RE: Lot 5 Block 6 Unit 19 Volcano Cliffs SAD 228 7816 Urraca St NW Building Permit Pad Certification

Engineers Stamp Date 1/3/17 (D10D003F25)

7816 Urraca Street, NW Grading & Drainage Certification

GRADING & DRAINAGE PLAN
7816Urraca Street, NW
LOT 5, BLOCK 6, UNIT 19 VCS

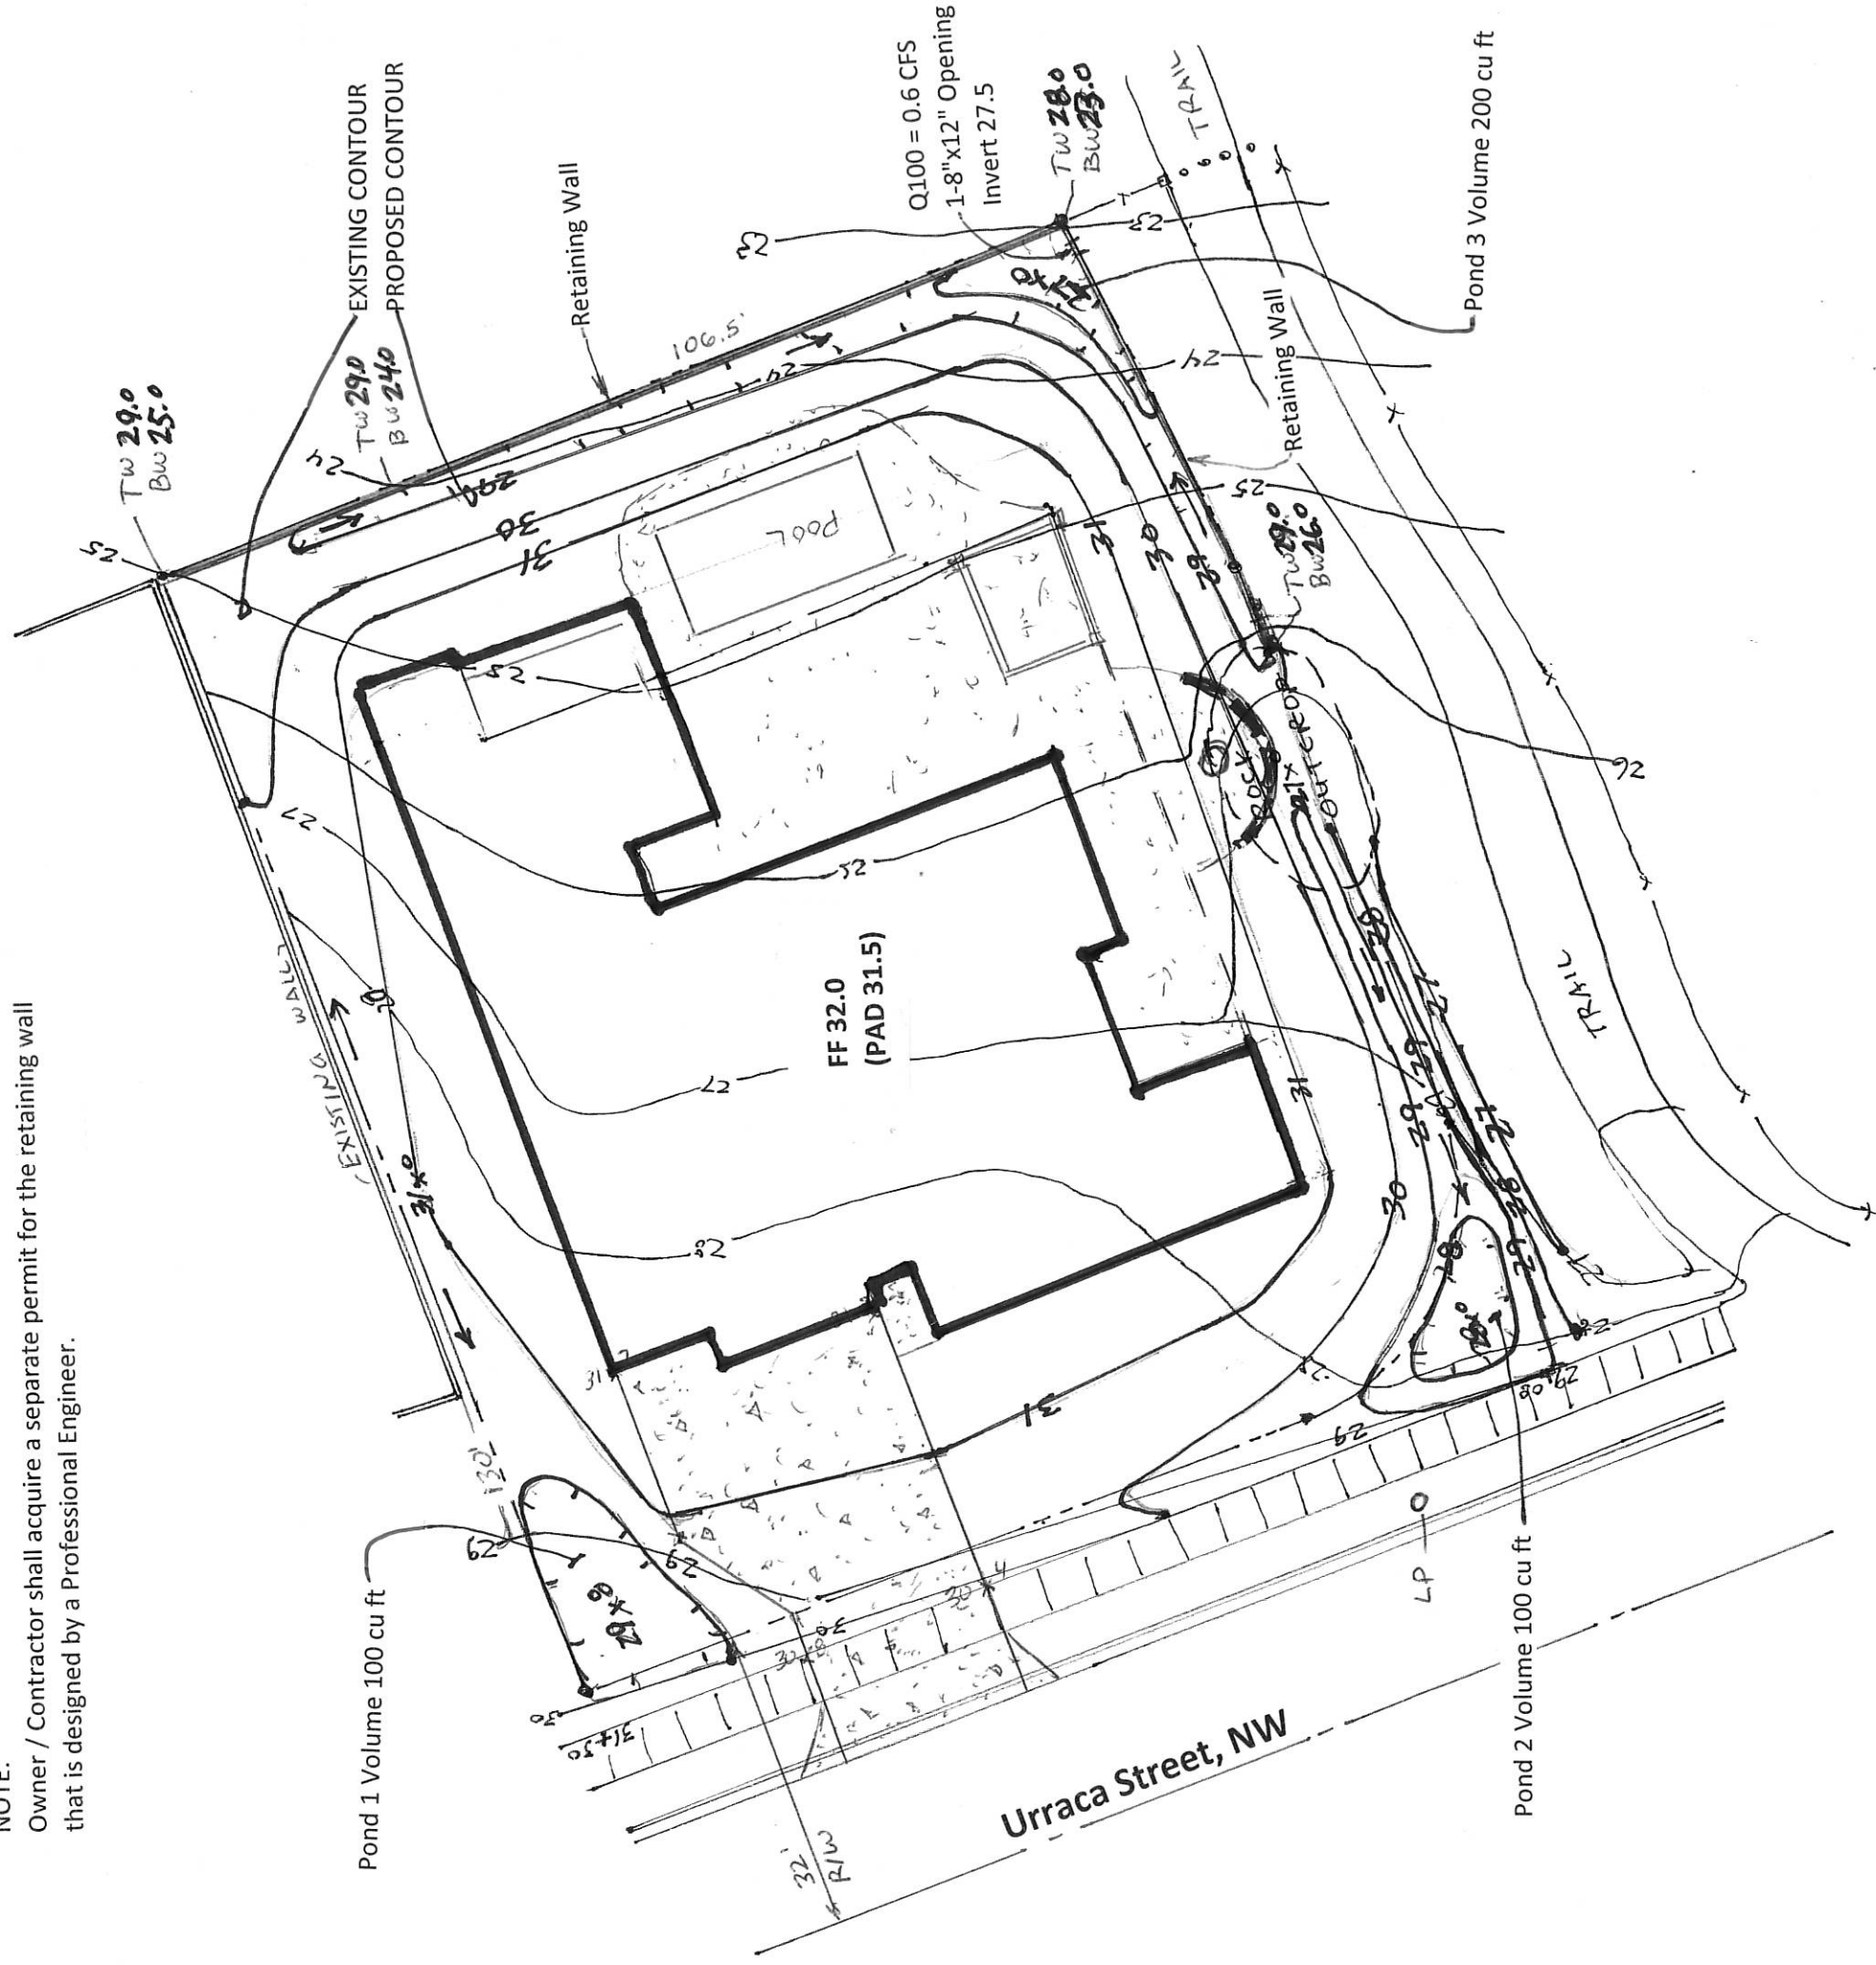
- Provide an opening in the NE corner of the wall if a block wall is to be built.
- Provide a note stating that all walls/fences require a separate permit.
- Provide a note stating that a pad certification is required before slab is poured.
